Our Ref: F/2/20/PL
Your Ref:

Town & Country Planning Act 1990 (as amended)
Town and Country Planning (Development Management Procedure) (England) Order 2015
Application for Planning Permission

Development Change the use of 1/2 the site area to a hard standing storage area (resubmission following F/9/19/PL).

Location Land Adjacent Station Cottages Ford Road Ford

Site boundaries
Owner T Luckin
Agent BCS 07917040175
Proposed change of use
scale 1:1250

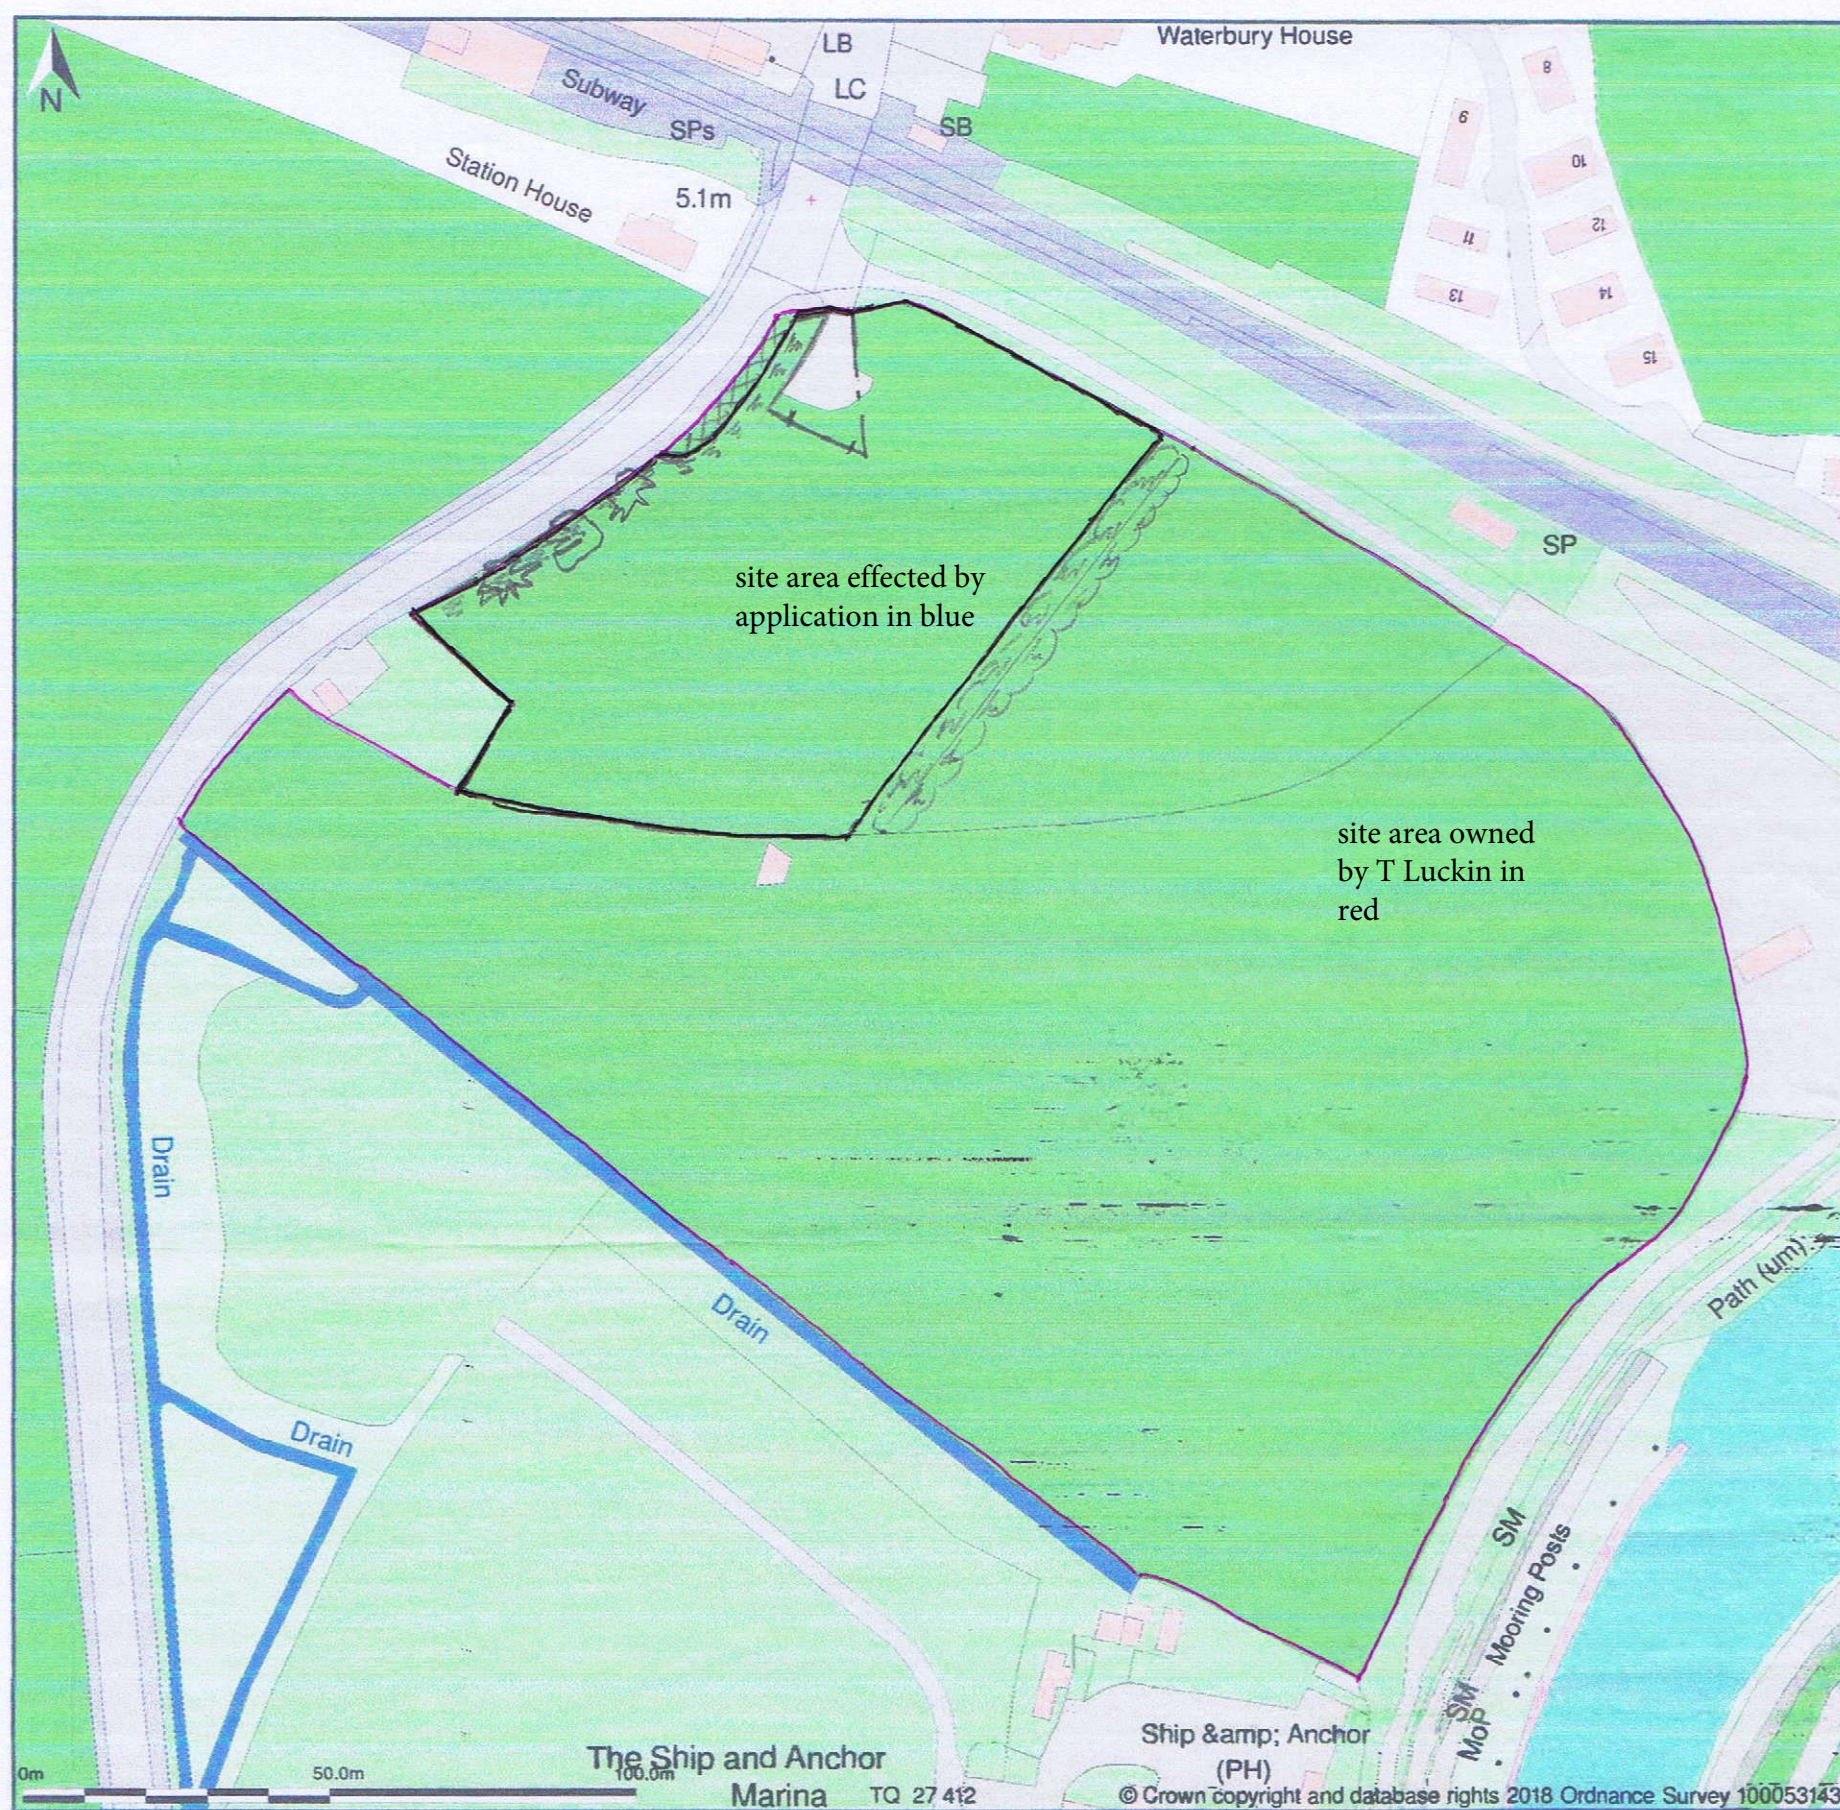
Location Plan Amend

Please only red edge the application site and blue edge any other land owned/in control of applicant and provide one named road.
